From: Rich Elliott <elliotttr@kvfr.org>
Sent: Tuesday, May 24, 2016 9:39 AM
To: Jeff Watson
Cc: Joe Seemiller; John Sinclair; Josh Hink
Subject: RE: Notice of Application: SP-16-00002 McElliott

Cc: Doc Hansen
Subject: Notice of Application: SP-16-00002 McElliott

NOTICE OF APPLICATION:

Kittitas County Community Development Services has received the above referenced application for a Short Plat NE of Ellensburg on Brick Mill Road in the lower county. See attached documentation for additional information or use one of the hyperlinks above to access the on-line or network file. Comments within the body of an email are encouraged but may be sent as attachment or via USPS as a hard copy.

# McELLIOTT AGRICULTURAL SHORT PLAT PART OF SECTION 20, T. 18 N., R. 19 E., W.M. KITTITAS COUNTY, WASHINGTON

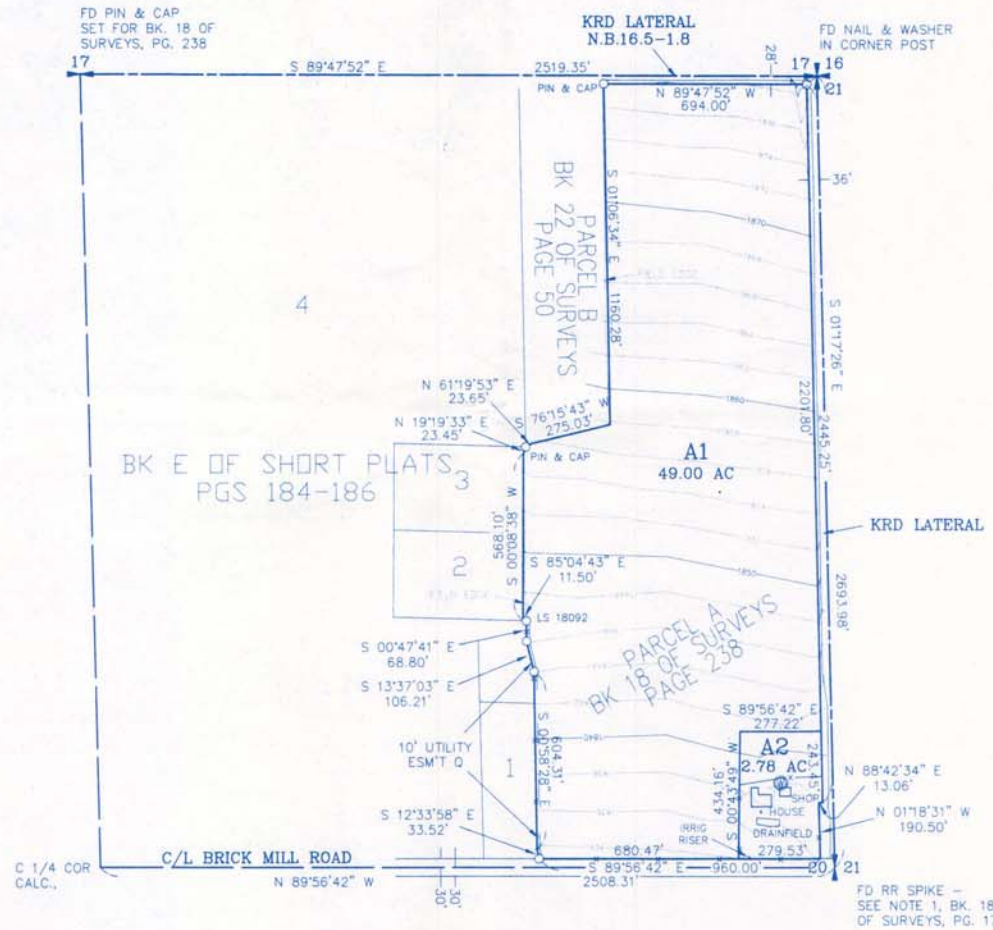
After fire department review, we have the following recommendations to be considered during permitting process:

1. Addressing for two parcels needs to be clearly visible from both directions of travel on county road.
2. Access to all structures needs to be compliant with current IFC – Appendix D.
3. If any creek or irrigation waterway is to be crossed by bridge, it will need to be engineered and posted for 75,000lb capacity.
